Recommendation Report for Planning Permission for Works or Extension to a Dwelling

REF NO: BR/108/21/HH

LOCATION: 49 Chestnut Grove
Bognor Regis
PO22 9JF

PROPOSAL: Erection of single storey rear extension and side porch

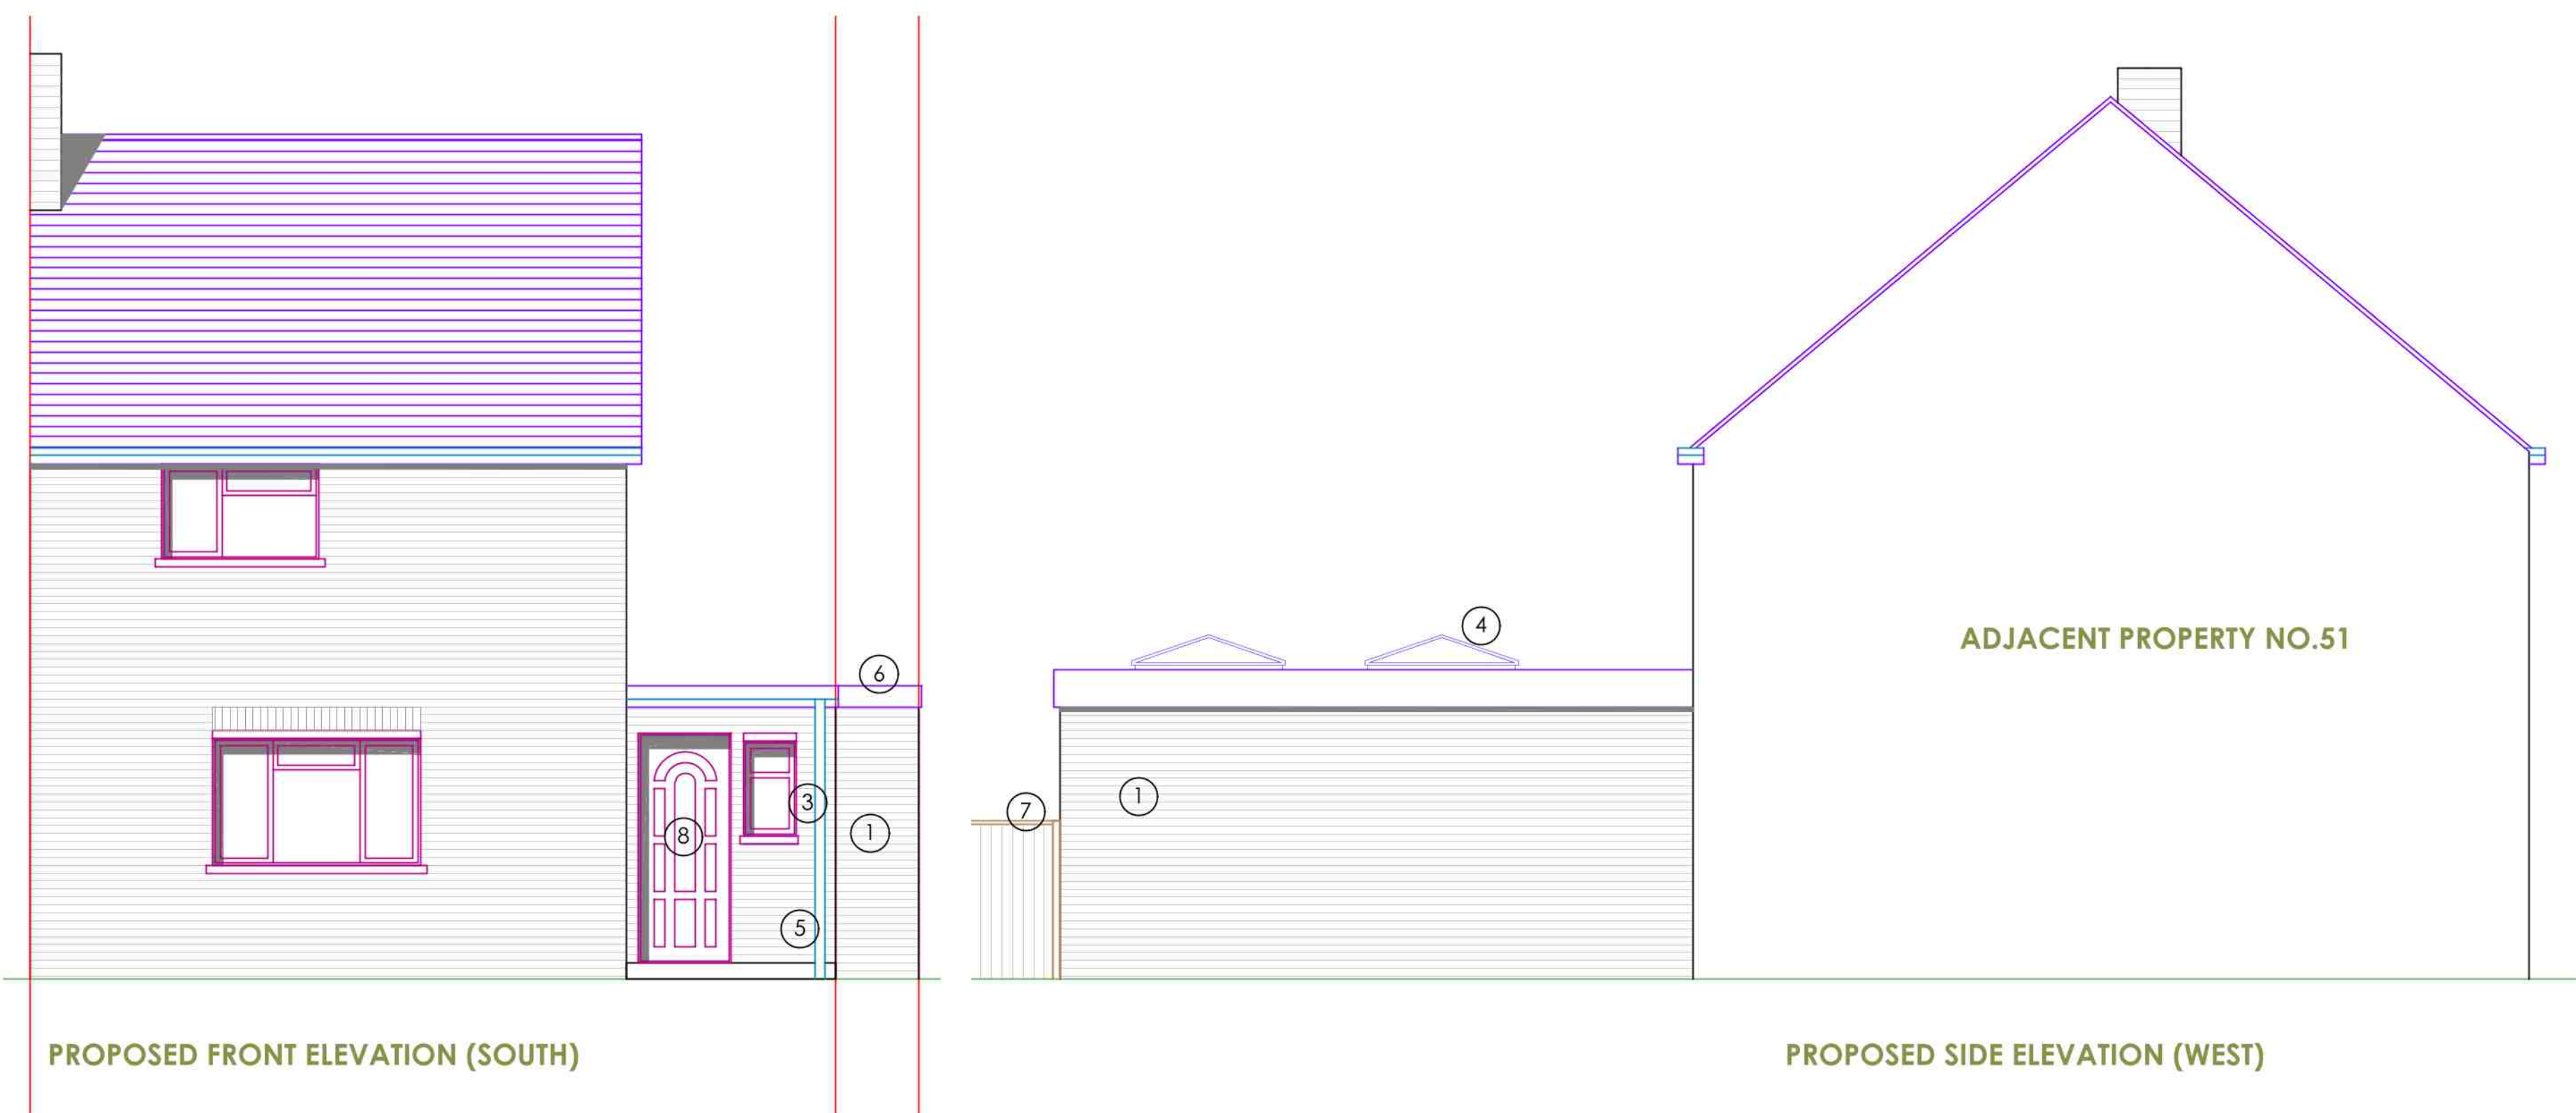
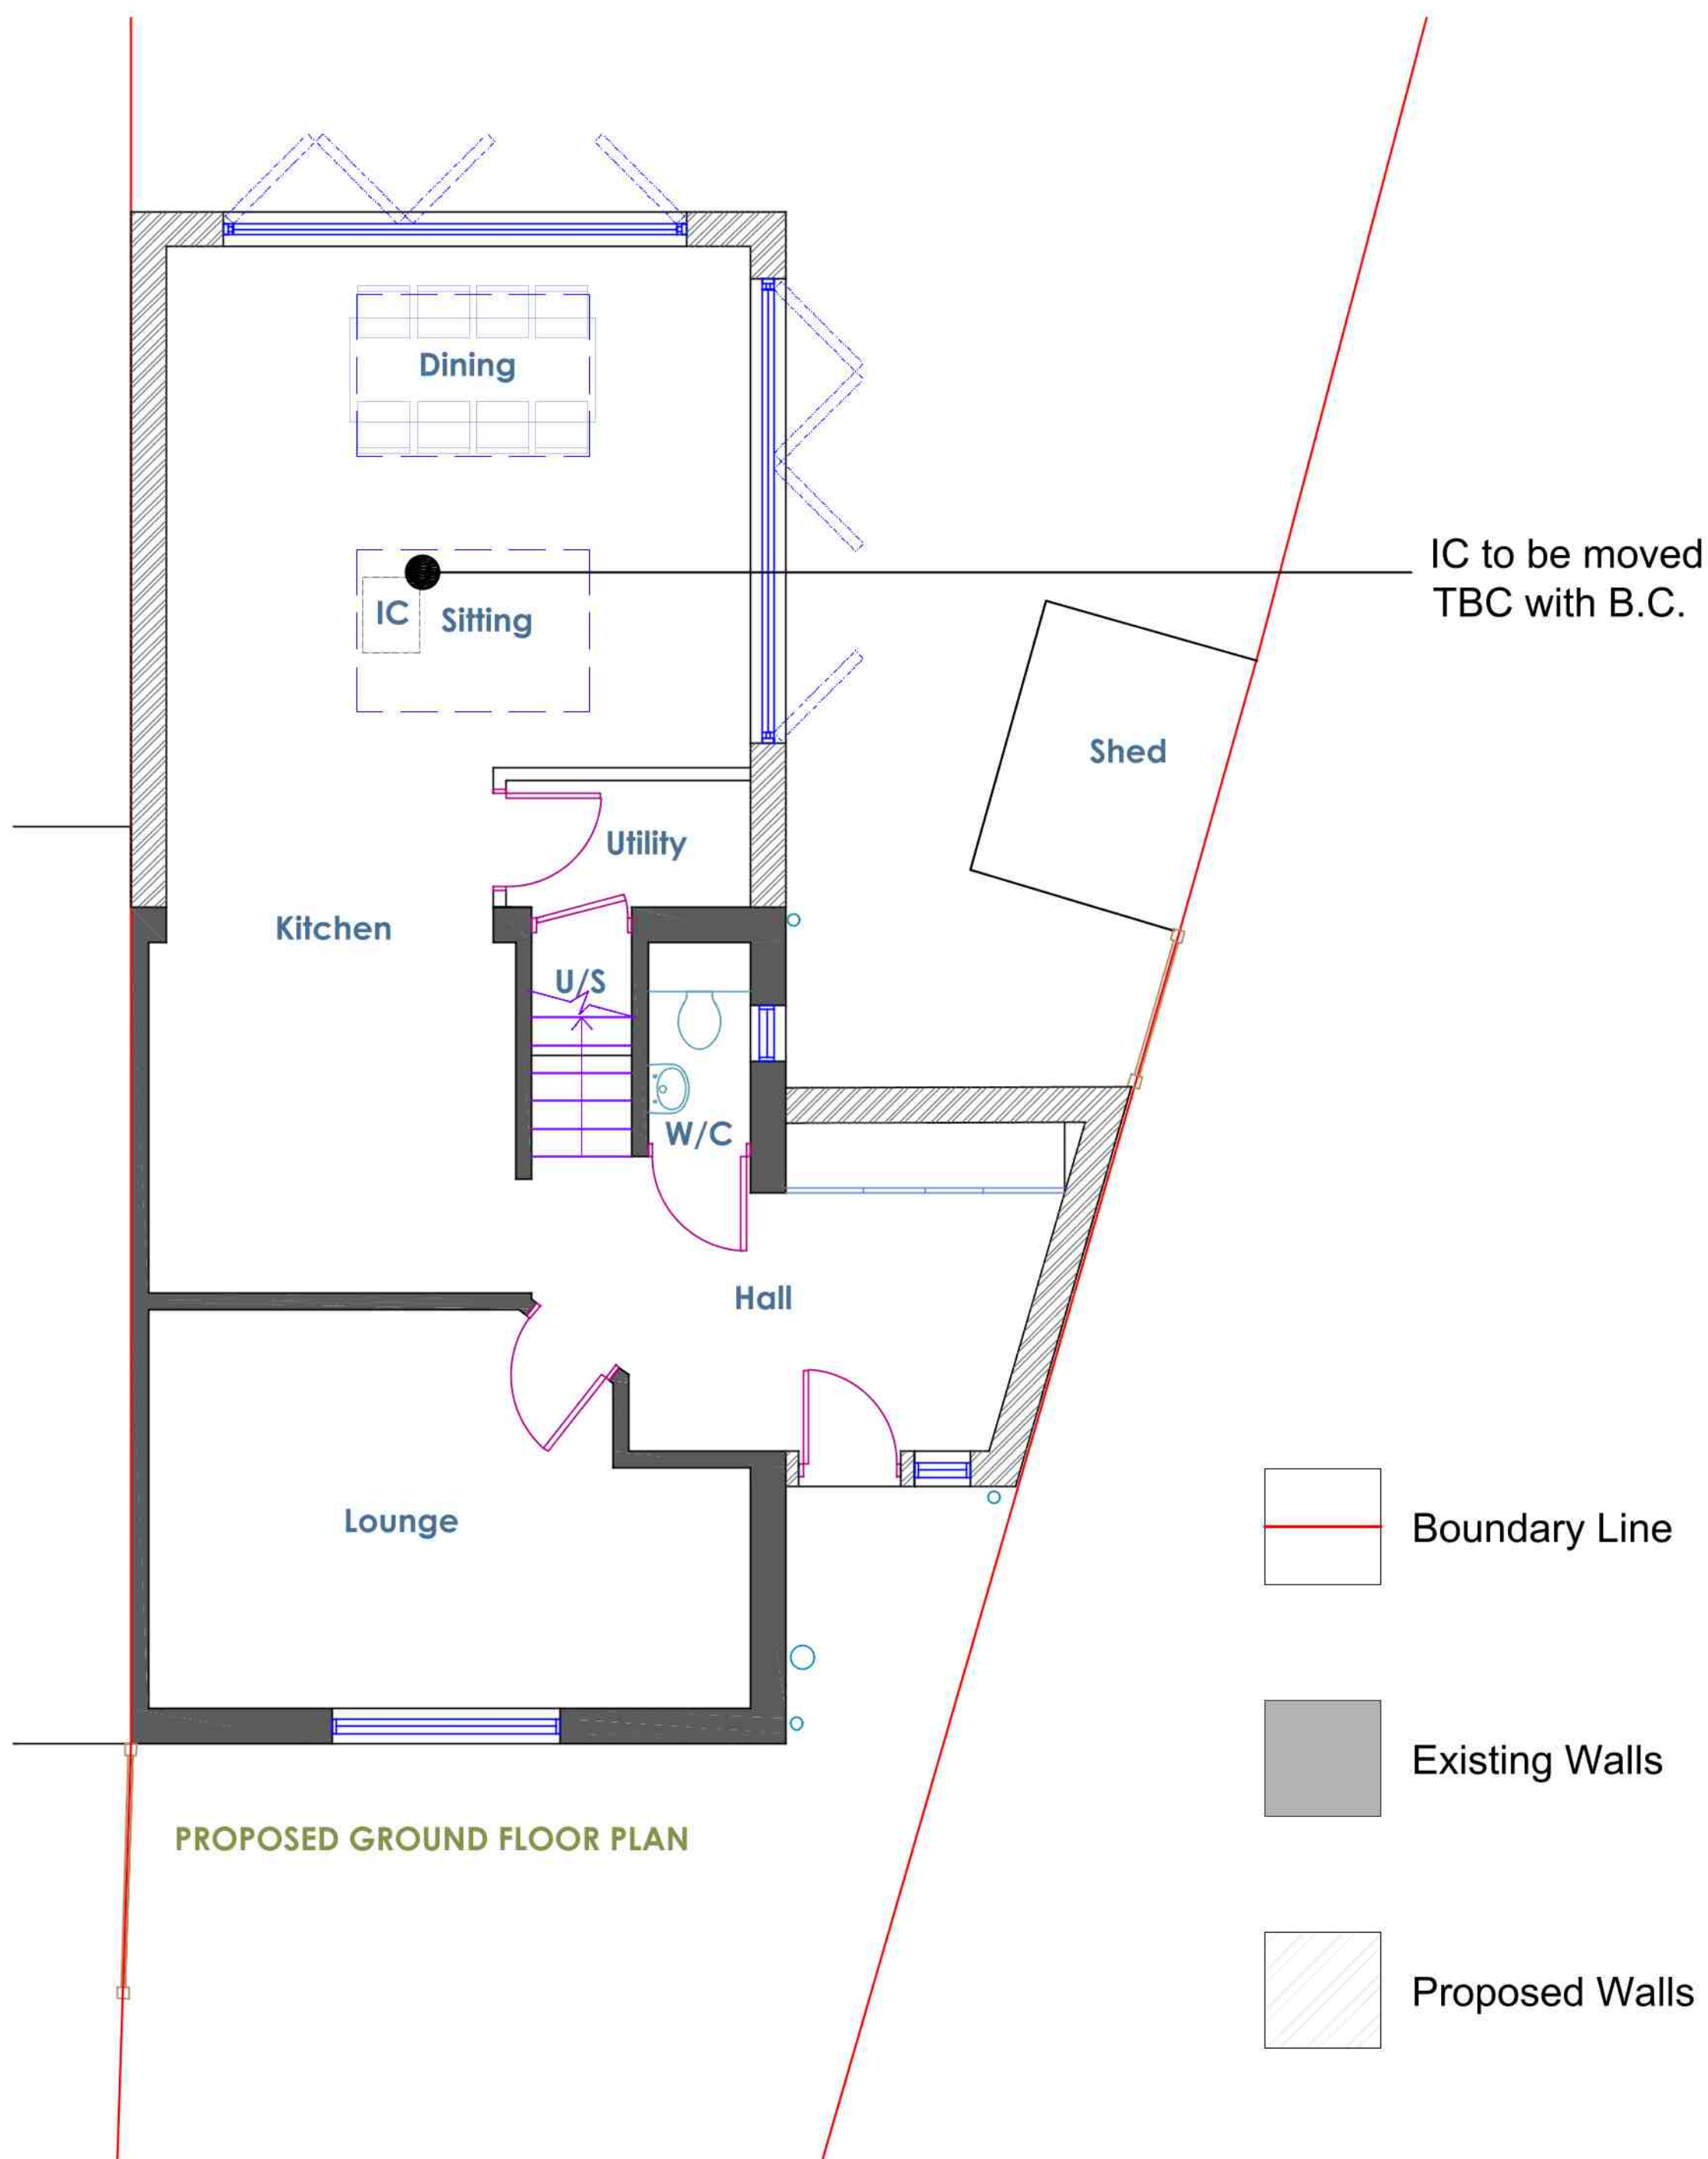
The single storey rear extension will have a width of approximately 5.62m and a depth of approximately 5.99m. The height to flat roof will be approximately 2.94m (3.23m to top of roof lights). There will be double bi-fold doors on the rear elevation facing the garden and double bi-fold doors on the east elevation facing the garden. There will be 2 new roof skylights.

The side porch has a width of approximately 3.58m and a depth of approximately 3.01m. The height to flat roof will be approximately 2.82m. There will be a front door in the south elevation and a new window in front (south) elevation facing garden area to front.

The proposal does not comply as it extends further into garden (5.99m) from rear elevation of original dwelling however a 3m extension can be done as permitted development and 6m as extended permitted development with a prior notification application so the impact on the property to west will not be much different to that achievable via a "fall back" position.

The rear extension will have a width of approximately 5.62m and a depth of approximately of 5.99m. The height to flat roof will be approximately 2.94m and to top of roof light will be 3.23m. Due to the siting at the rear of the property there will be increased effects of overshadowing or overbearing effects to 51 Chesnut Grove. However the design being single storey and the depth are similar to that which could be achieved under permitted development.

The proposal does not comply as it extends further into garden (5.99m) from rear elevation of original dwelling and conflicts with the 45 degree test to ascertain if the proposal affects neighbours access to light. However a 3m extension can be done as permitted development and 6m as extended permitted development with a prior notification application so the impact on the property to west will not be much different to that achievable via a "fall back" position. Whilst there will be an impact on no 51 in the morning due to some overshadowing this is not sufficient to result in a refusal.

Due to new bi-fold doors in north elevation of extension there is increased risk to overlooking to neighbouring properties to west however due to siting of extension it is beyond building line to west so will not cause adverse harm to overlooking to neighbouring property to west. Due to a gap of 9m remaining to north boundary of site and no direct neighbours to north and existing boundary fence there is no harm to overlooking to neighbouring properties to north. Due to new bi-fold doors in east side elevation of extension there is increased risk of overlooking to neighbouring property to east however due to gap of approximately 5.18m remaining to east side boundary and property to east set back there is no adverse harm to overlooking to property 47 Chestnut Grove to east so is acceptable.

The side porch will have a width of approximately 3.58m and a depth of approximately 3.01m. The height to flat roof will be approximately 2.82m. Due to the siting of porch on east side of property there is increased risk to overshadowing or overbearing effects to neighbouring property to east however due to being at single storey and neighbouring property set back from east side boundary there is no adverse harm to overshadowing or overbearing effects to neighbouring property to east.

Due to new single window to front (south) elevation of porch extension and new front door on south elevation there is increased risk to overlooking to neighbouring properties to south however due to being set back from road by around there is no adverse harm to overlooking effects to neighbouring properties to south east so is acceptable.
